PRELIMINARY DRAINAGE REPORT FOR BRADLEY POINT FILING NO. 1

EL PASO COUNTY, COLORADO

PCD-ENGINEERING REVIEW COMMENTS
IN BLUE BOXES WITH BLUE TEXT

MS-21-002

GRADING AND EROSION CONTROL PLAN
DECEMBER 2020

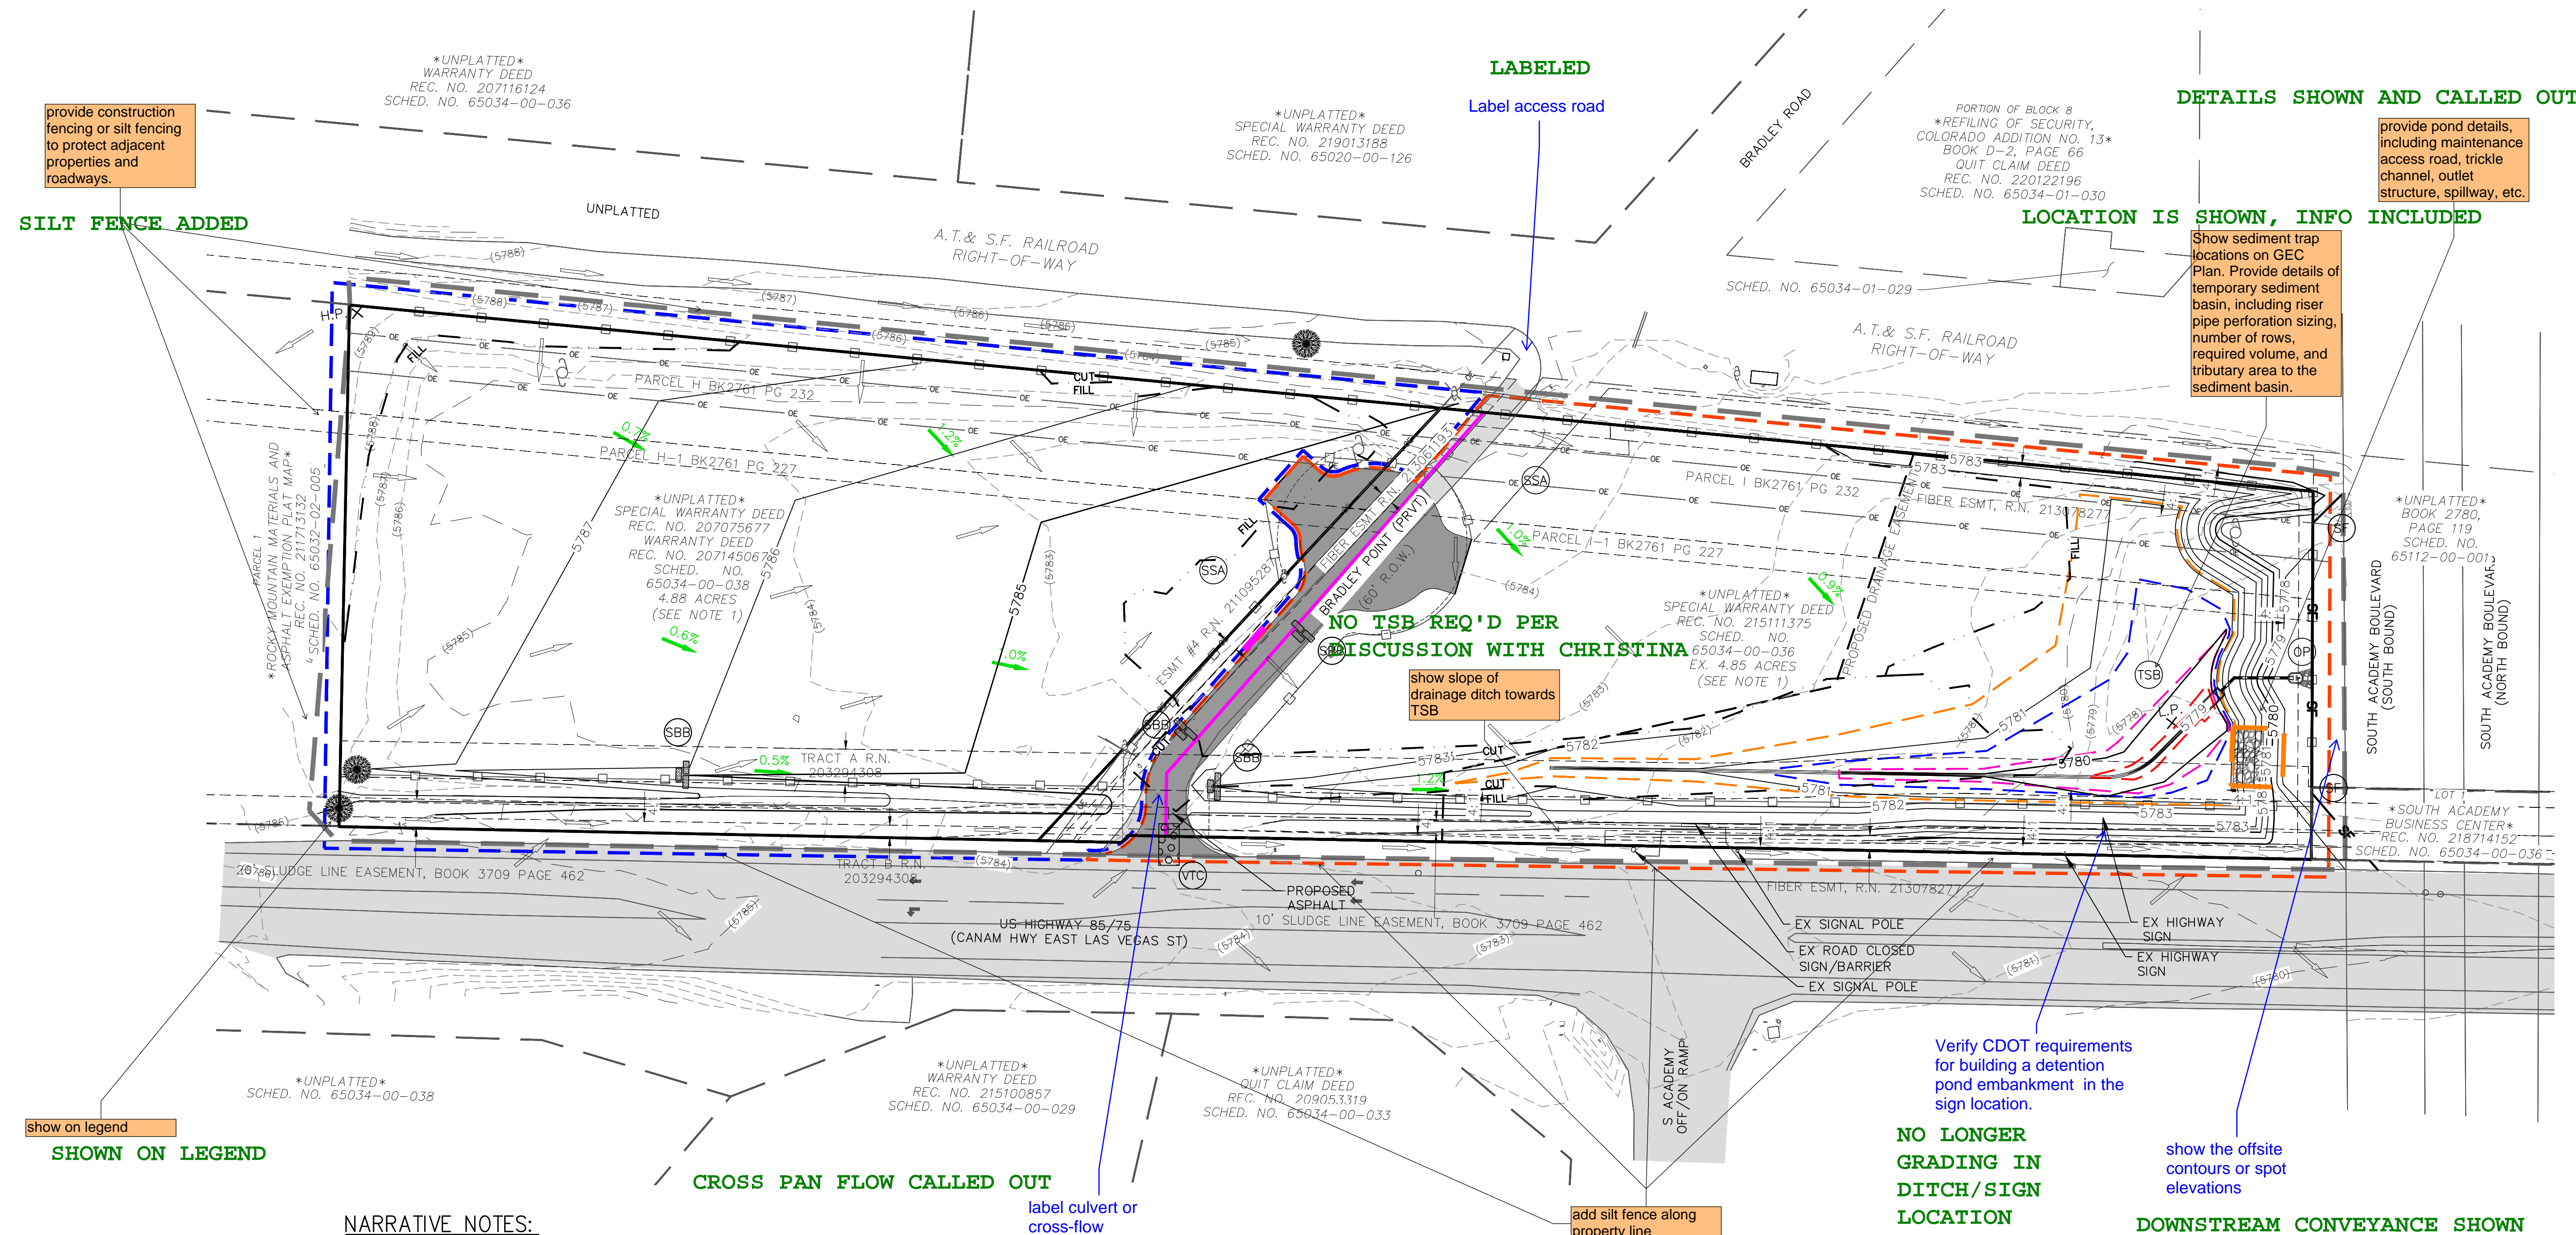
The grading plan shows regrading - will this just be gravel?

how does it cross
the access road?

REVISED

REVISED, CROSS PAN
